CITY OF PORTLAND

BUILDING PERMIT

Job ID: **2012-06-4241-ALTCOMM**

has permission to Remove section of retaining wall next to left wall of building & replace with concrete stairs 10'6" x 5'6" provided that the person or persons, firm or corporation accepting this permit shall comply with all of the provisions of the Statues of Maine and of the Ordinances of the City of Portland regulating the construction, maintenance and use of the buildings and structures, and of the application on file in the department.

JOB:	ISSUE DATE:
PRINT:	W/S/NO:
DESIGN BY:	DATE:
TITLE:	SCALE:
STAIR PLAN	1/4" = 1'-0"
1 SECTIONS	DRAWING NO.:
	A111

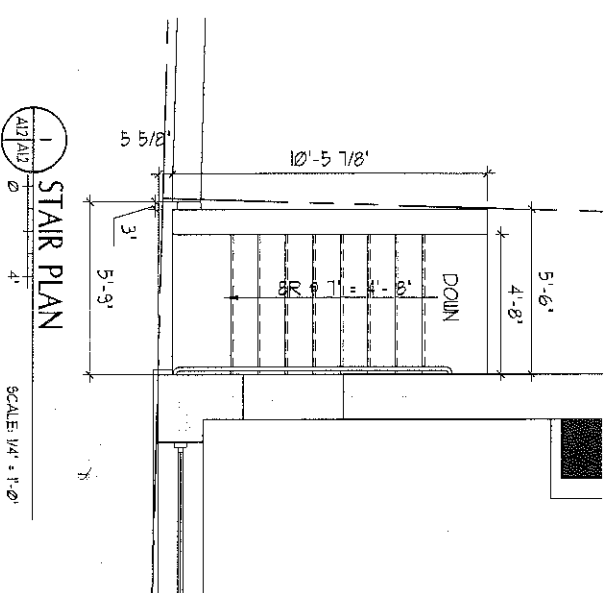
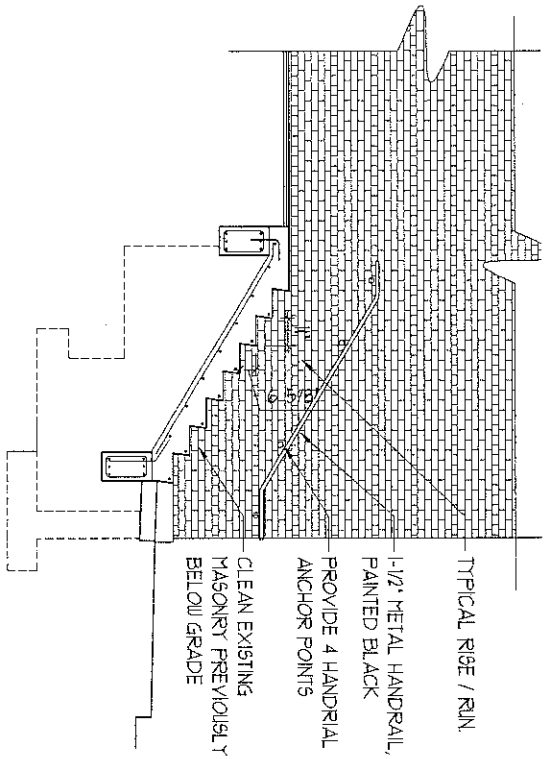
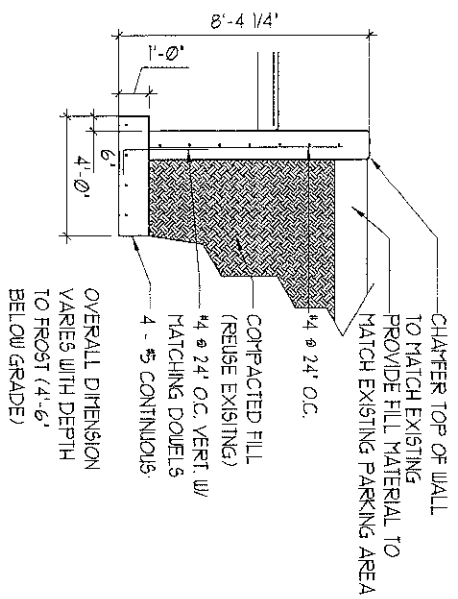
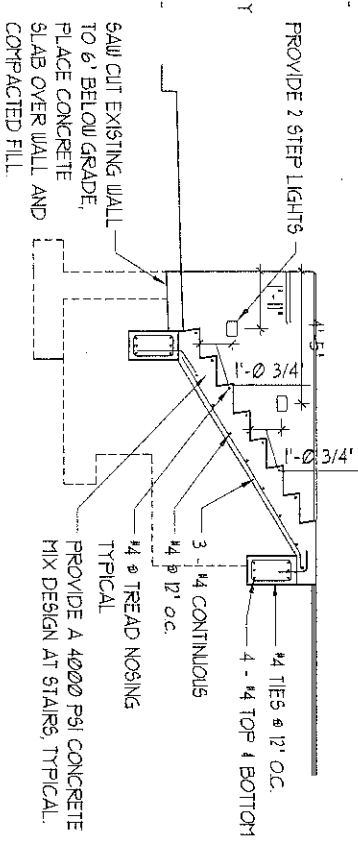
1. The section of metal fencing shown on the submitted plans shall be eliminated. Building Inspections Director, Tammy Munson, has confirmed that the fencing is not required by building code.

2. The new stairs shall not be physically attached to the abutting building. Installation of a single handrail within the building's mortar joints is acceptable. Handrail to be painted brick red to be visually recessive.

1. Installation shall comply with City Code Chapter 10.
2. A handrail is required on both sides of the stair.
